Sir Antony Gormley and Antony Gormley Studio

Responses to Deadline 9 Submissions

Outline CEMP

- KEY:**
- DCO Limits
 - Site Lines of Gantries From Angel of the North
 - Existing**
 - Vegetation Retained
 - Vegetation Removed
 - Trees Retained Within Areas of Clearance / Thinning

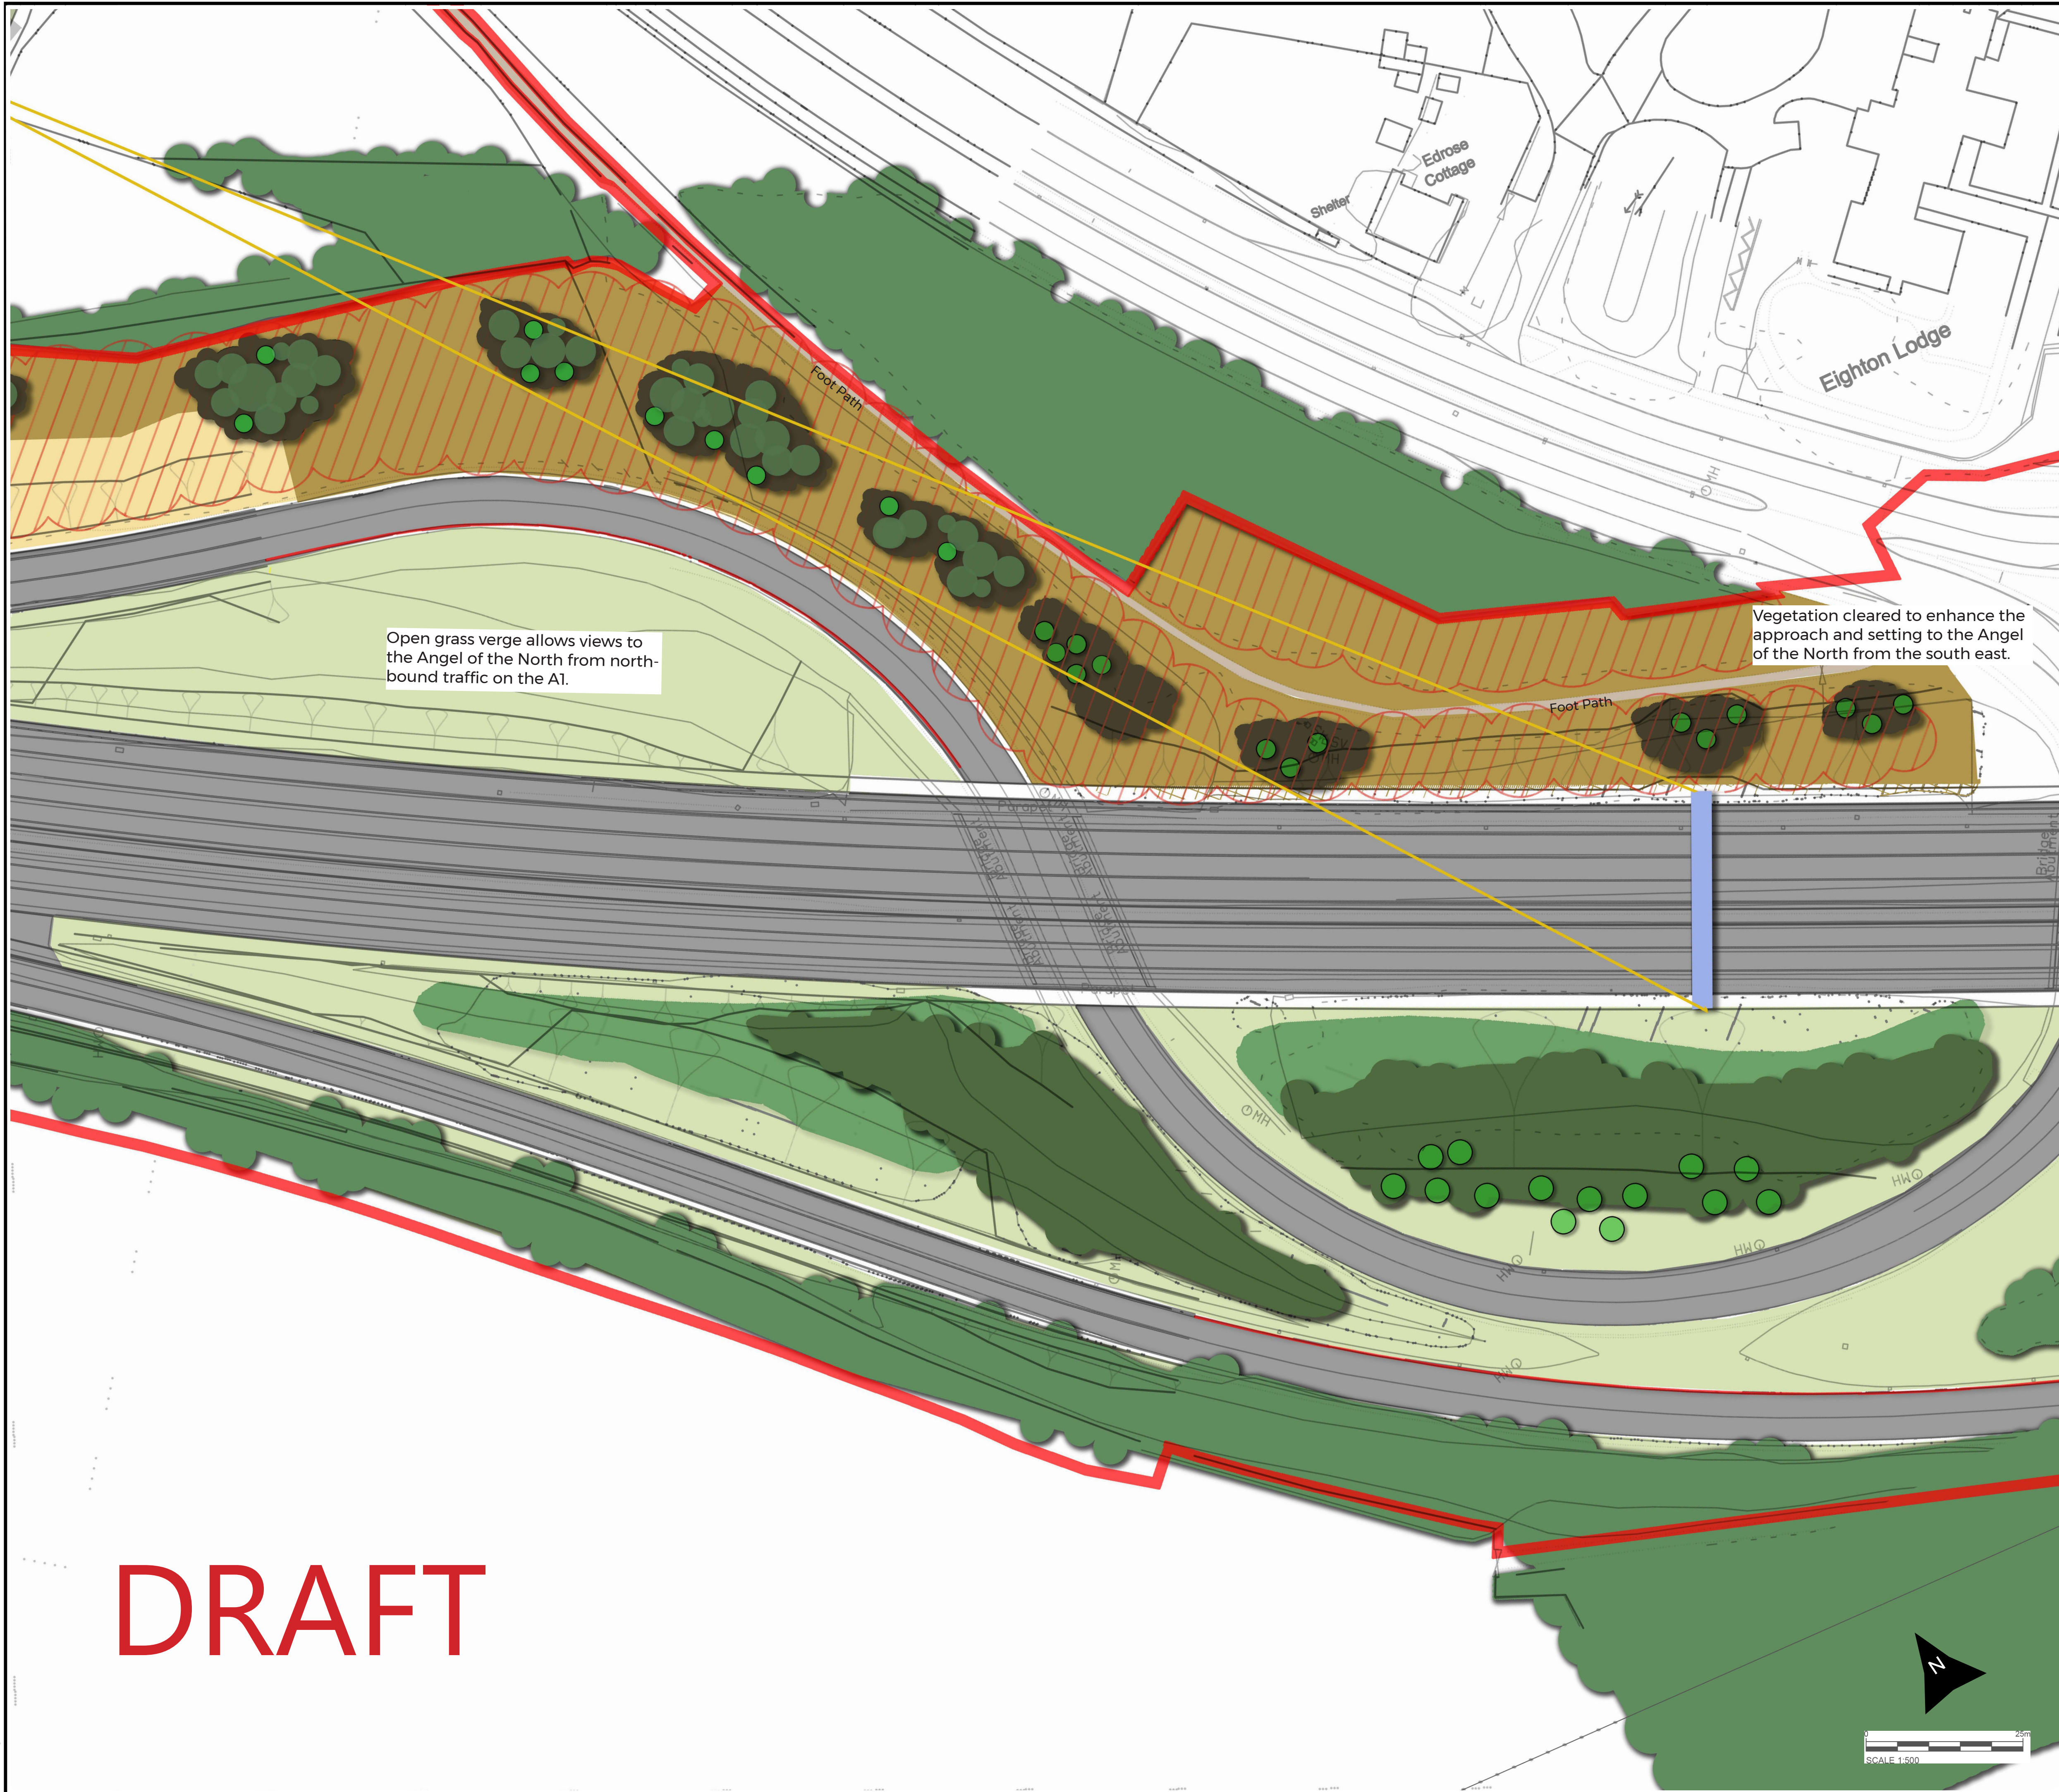
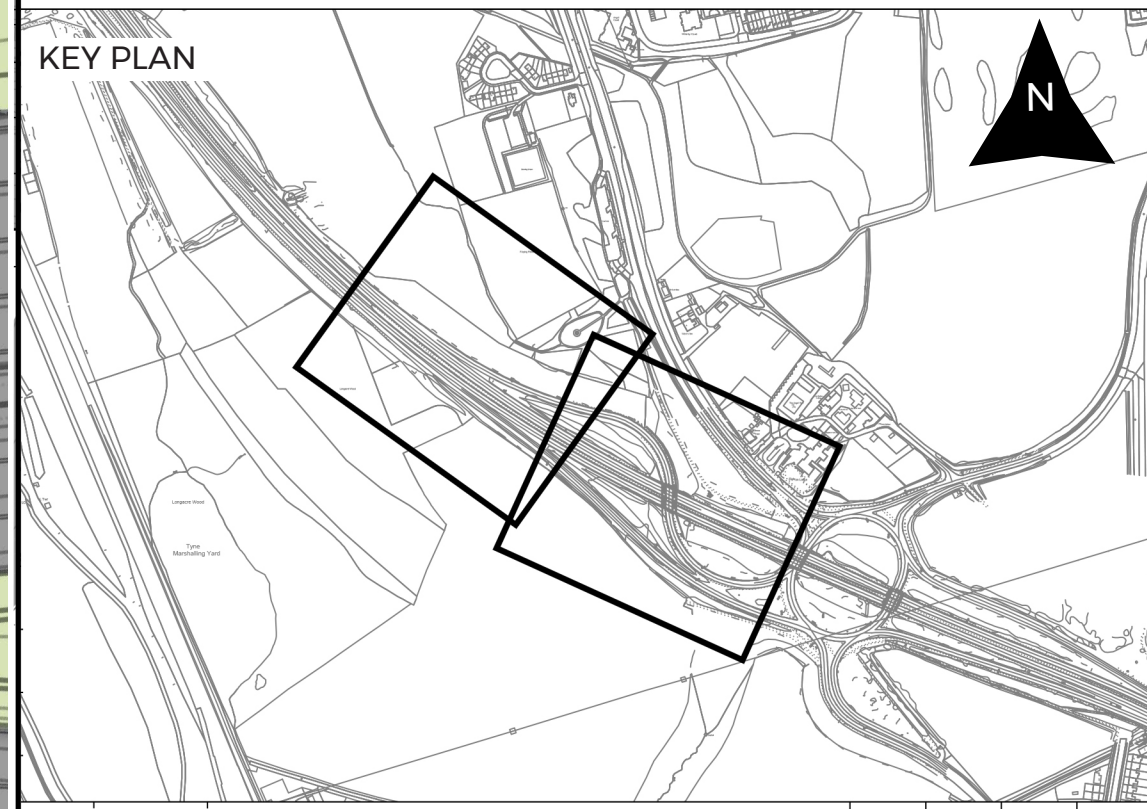
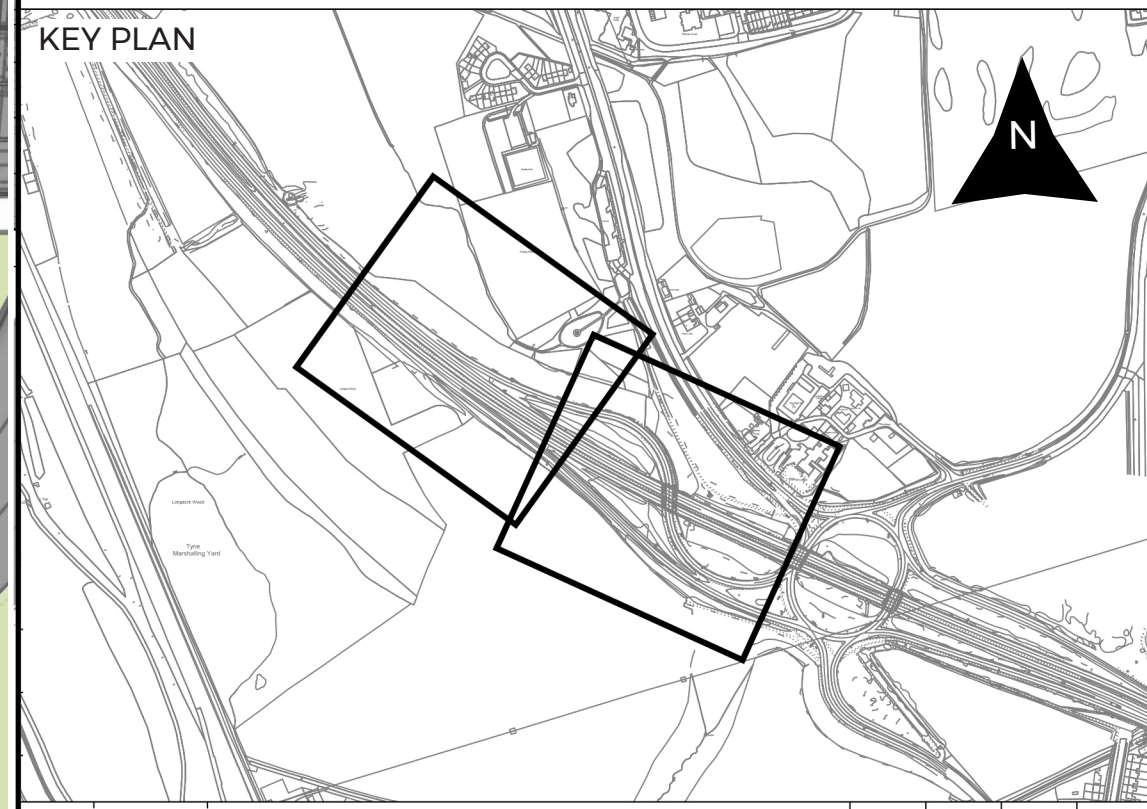
L14 – In response to the Landscape Mitigation Design we would support “thinning and pruning” of vegetation to allow for greater visibility of the Angel of the North.

We would support the proposition made by Gateshead Council for offsite replanting and the proposed location at Beggars Wood, by Lobley Hill, seems to be a very suitable location.

We would still like to receive further details on the species and locations of trees to be removed and replanted.
